Re: Drainage Memo – Relocate Drop Structure

This document is the drainage memo for Falcon Ranchettes Filing No. 1a (Meridian Storage). The previously approved Final Drainage Report for this project included a drainage analysis for improvements to the existing roadside ditch along Meridian Road.

The purpose of this memo is to identify if any analysis is necessary for the relocation of a grouted boulder drop structure as designed in the approved Final Drainage Report.

CHANNEL PLAN & PROFILE

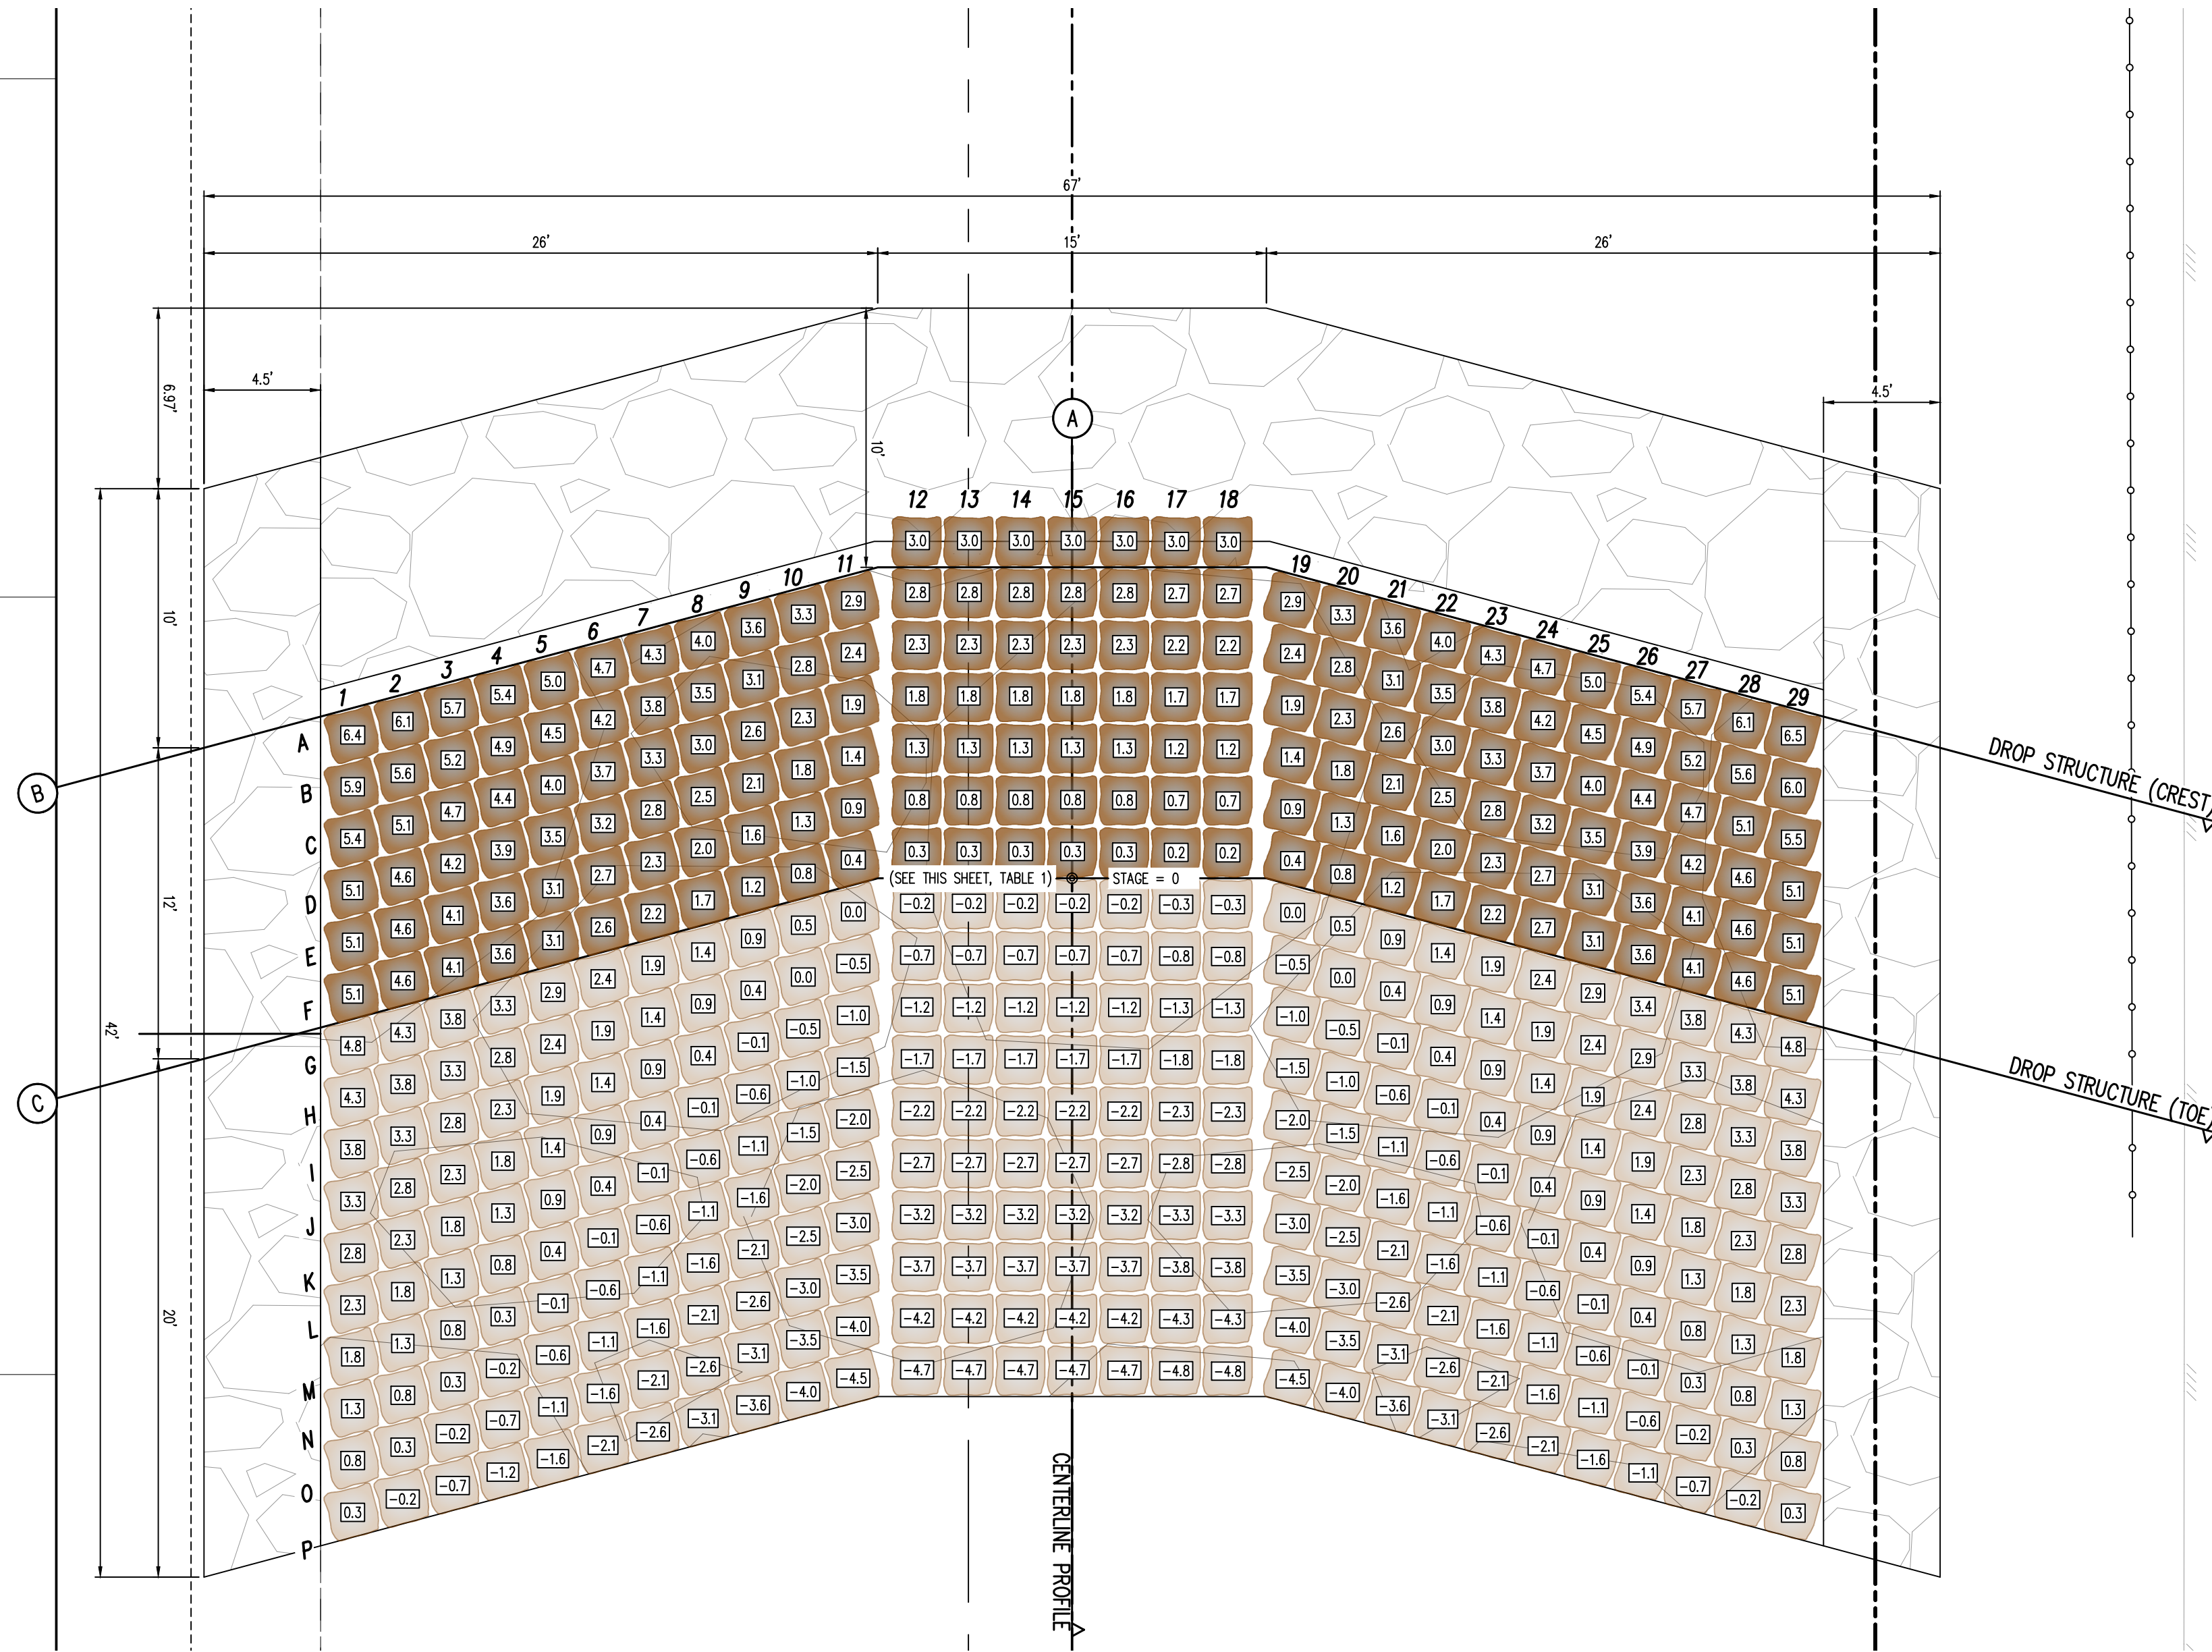
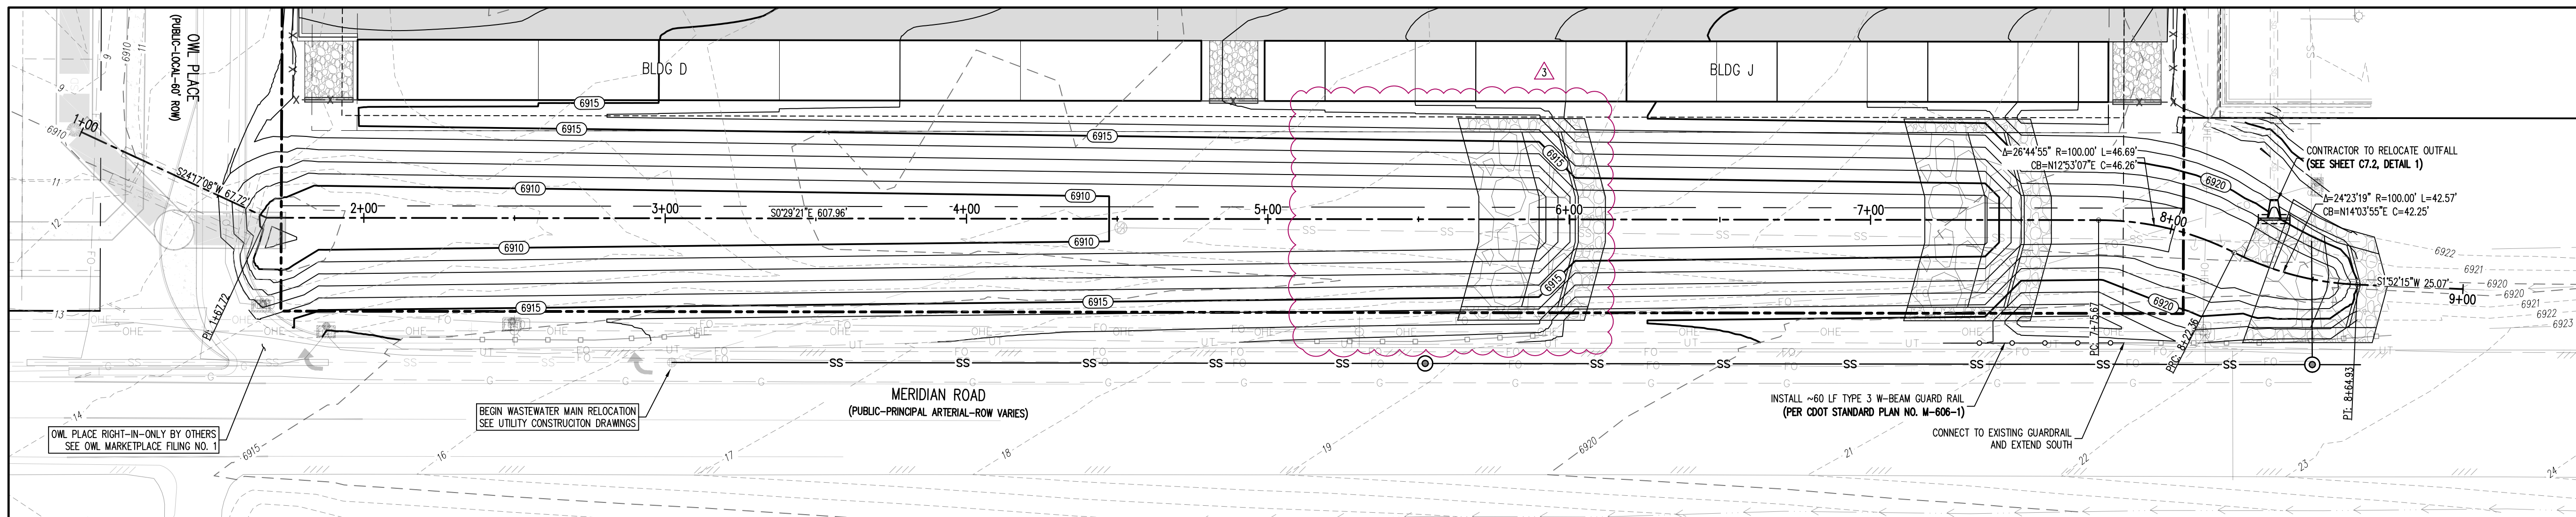
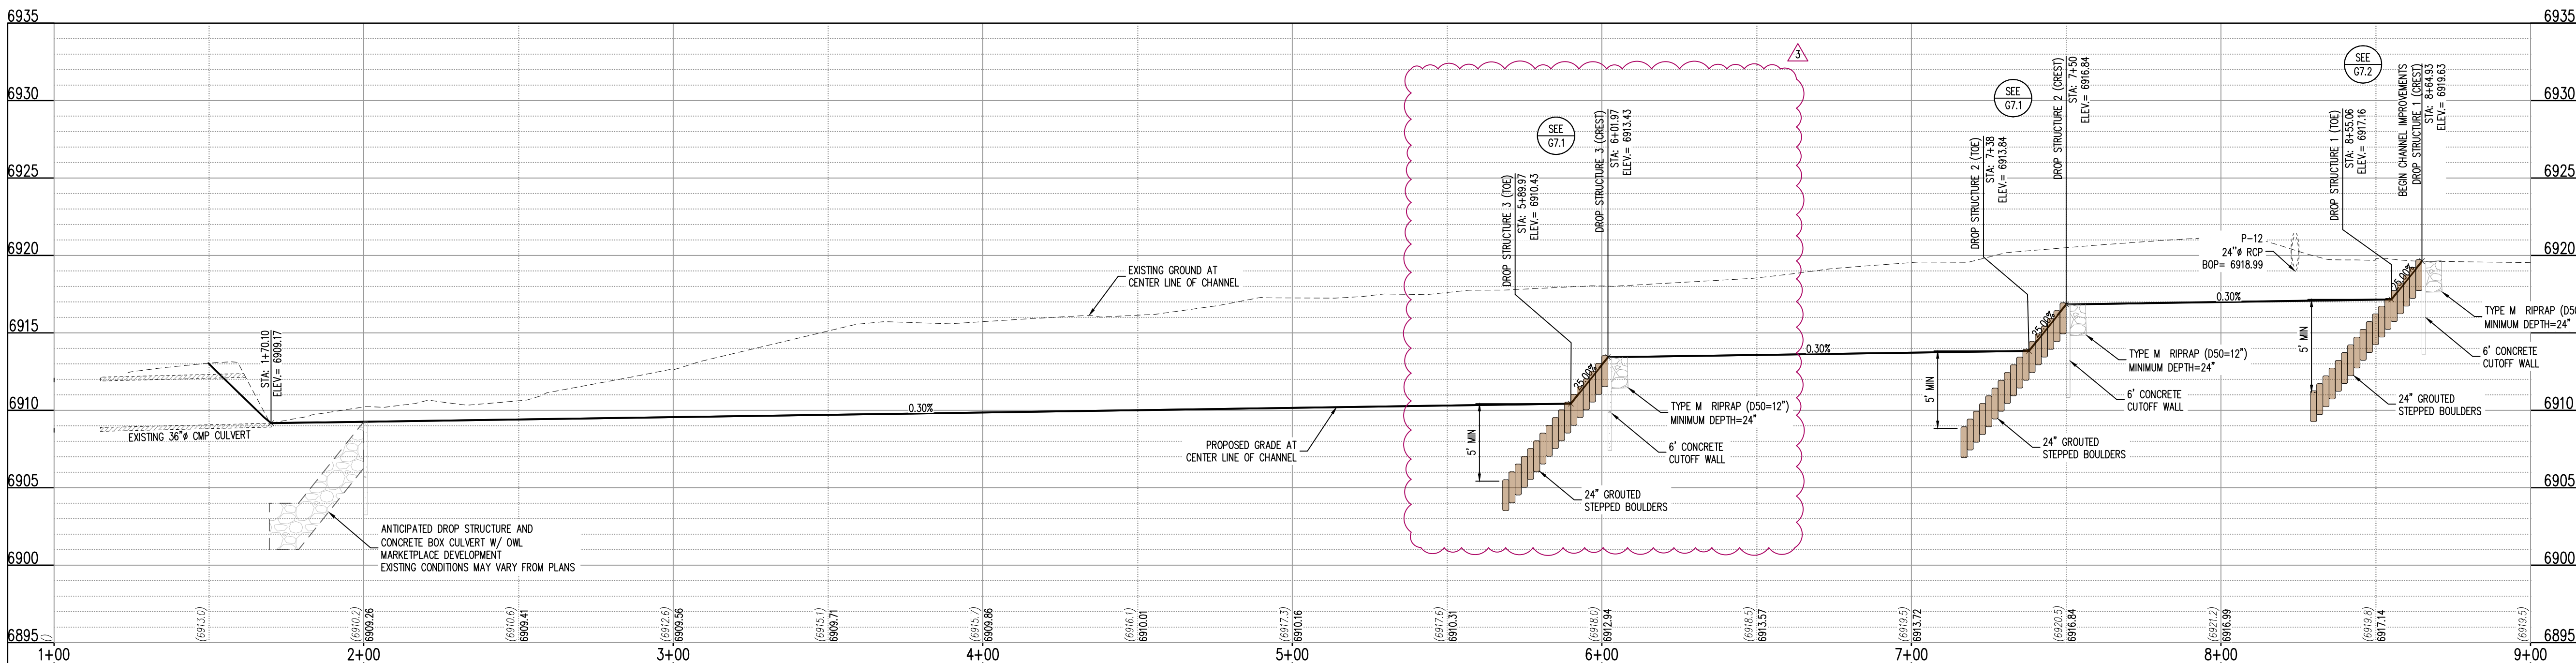
The relocated drop structure (shifted north approximately ~65 LF) imposes no changes to the design parameters nor criteria set forth in the USDCM and approved **FDR**.

In conclusion, the drainage channel will still function as intended with respect to the shifted drop structure.
